From: Simon Davis
Sent: 11 July 2018 09:23
To: Planning.Responses
Subject: FW: Sack Lane, Lidsey, West Sussex - Planning Application No. AL/60/18/DOC

2nd Drainage Engineers comments

Further to our e-mail correspondence last week, please find attached a copy of our revised drawing no. 18094/100'B', showing the amended underground drainage proposals for the above. I also attach further copies of our drawing no.'s 18094/101 and 102 showing drainage and pavement construction details.

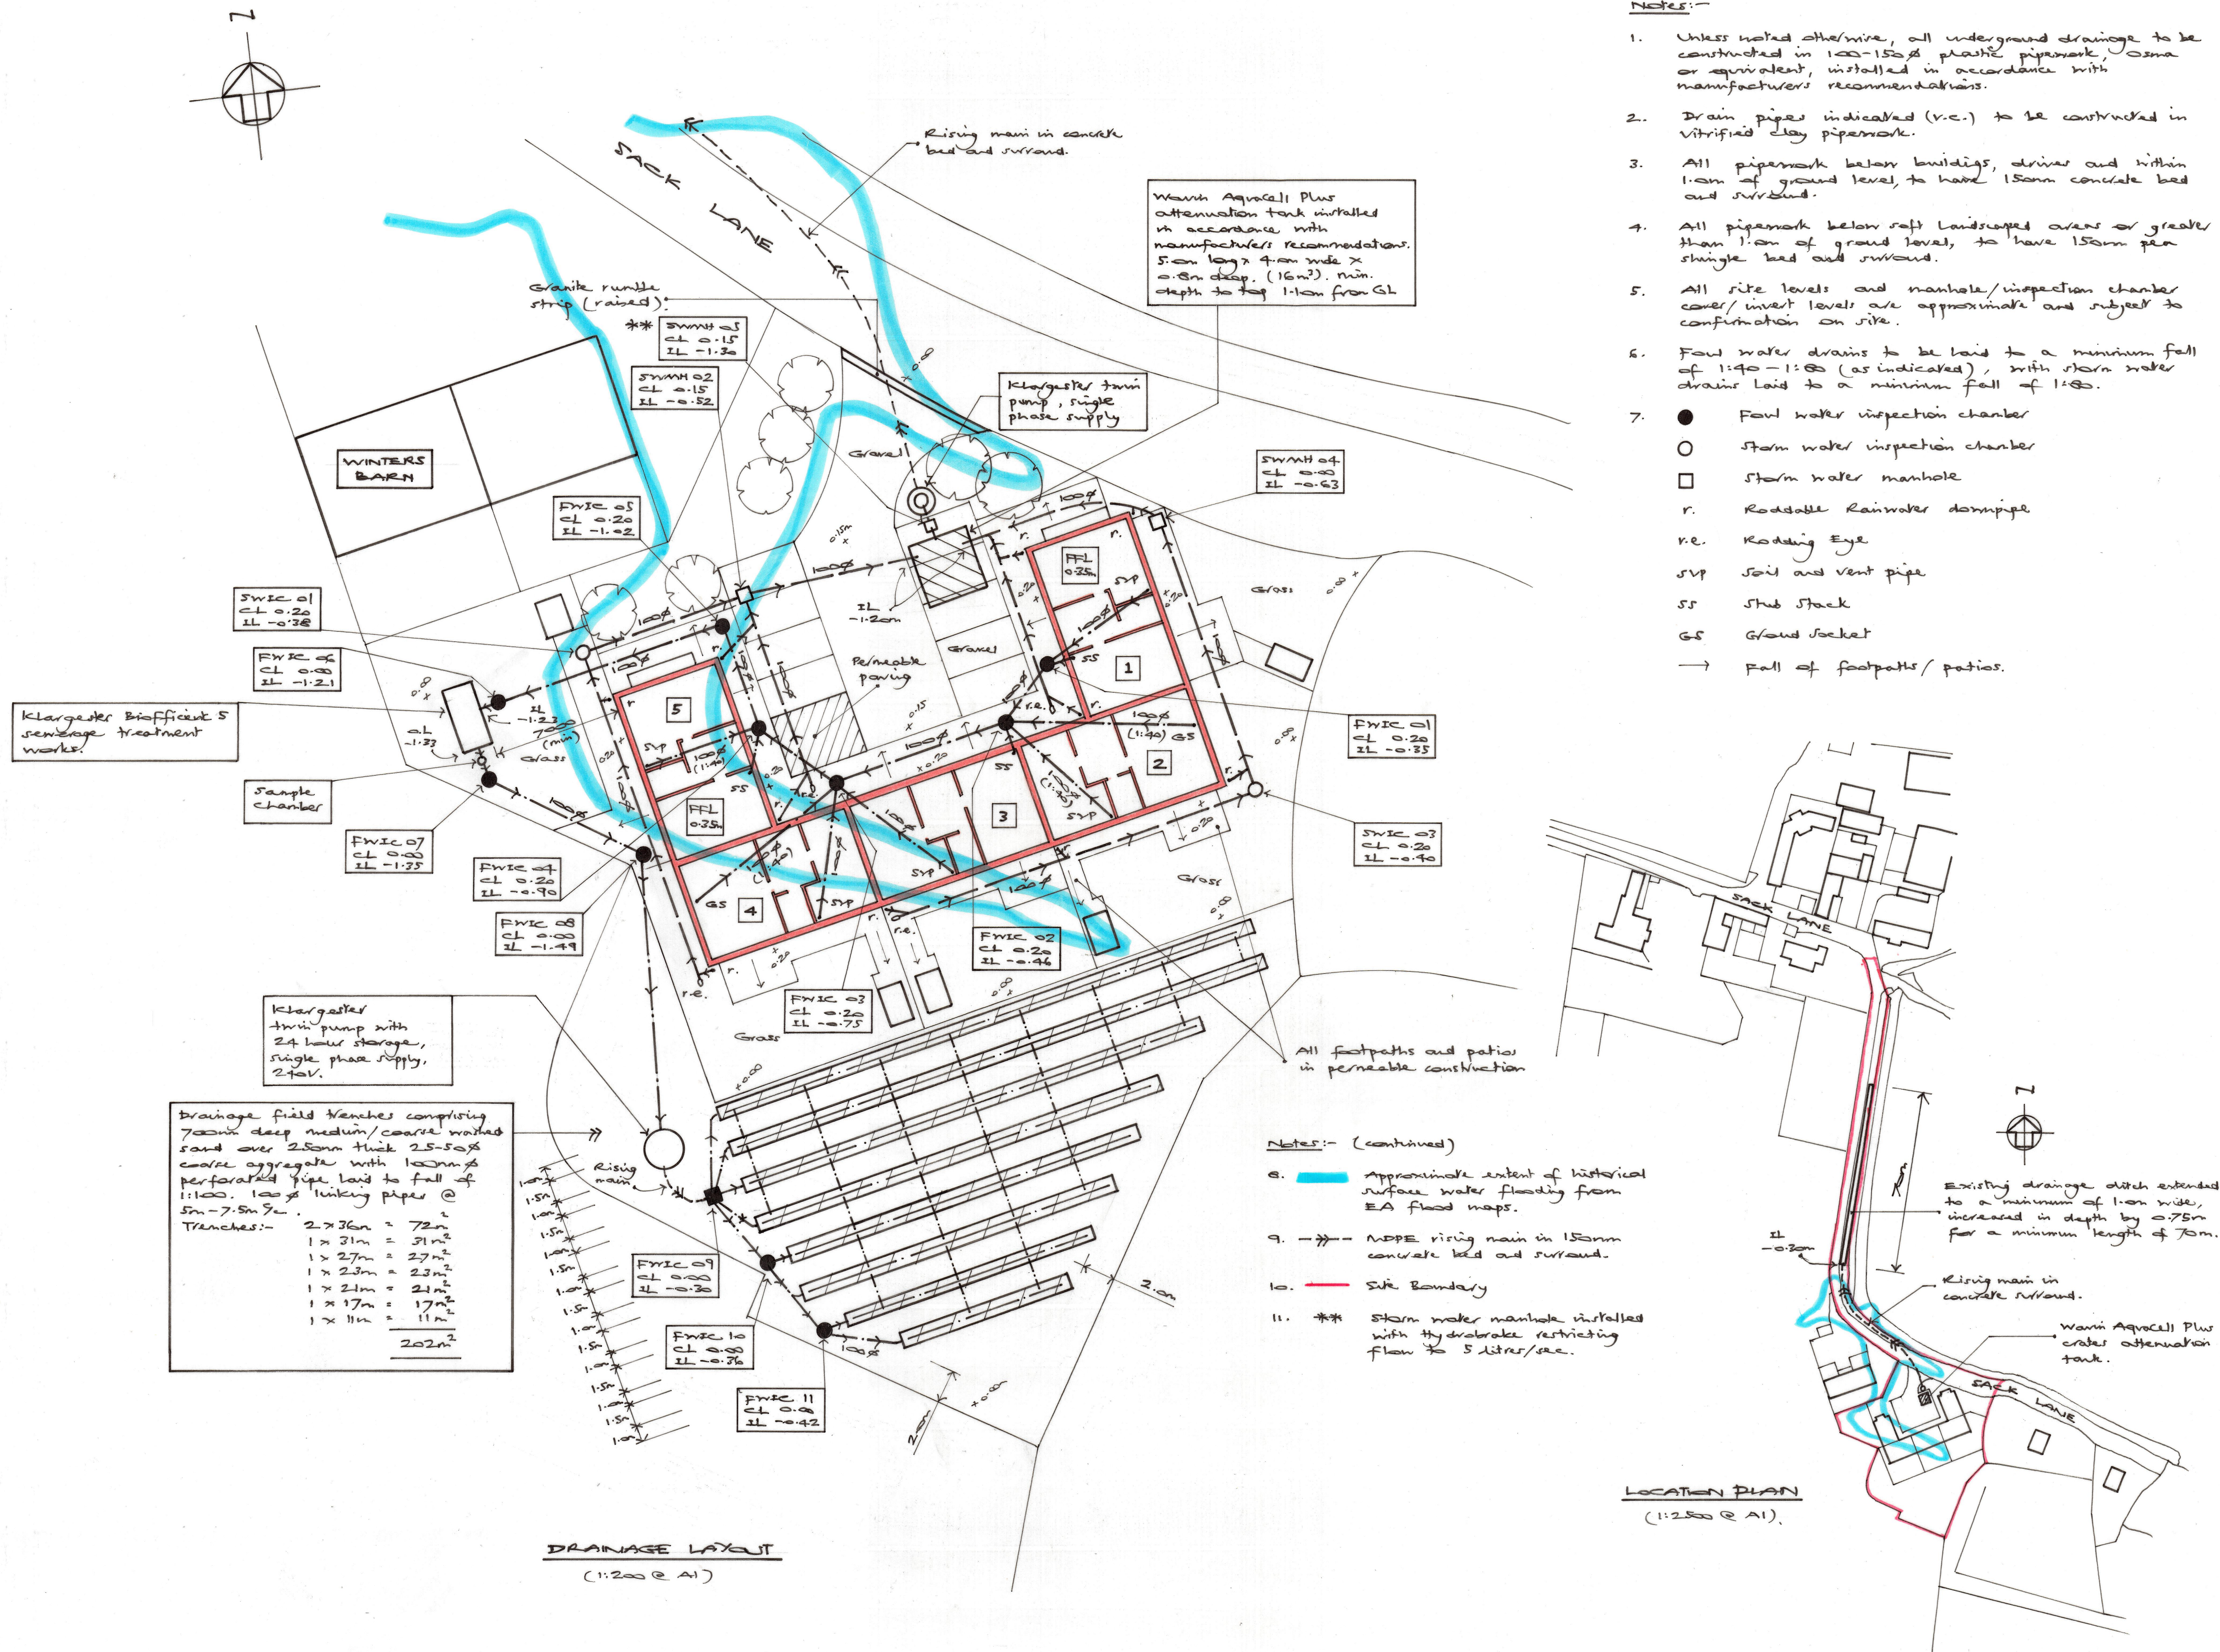
- Pumping is not a sustainable solution. This is a last resort measure that I feel there is currently insufficient justification for.
- Why can the surface water not be discharged via infiltration? Foul water final effluent is being infiltrated. Why not the surface water? This would remove the need for the surface water pumping.
- Winter infiltration testing is required to appropriately size the drainage. And winter groundwater monitoring is required to ensure invert levels of infiltration structures are set above the groundwater level.
- There is no detail demonstrating how the discharge of surface water is controlled. I.e. hydrobrake, orifice, pumping rate.
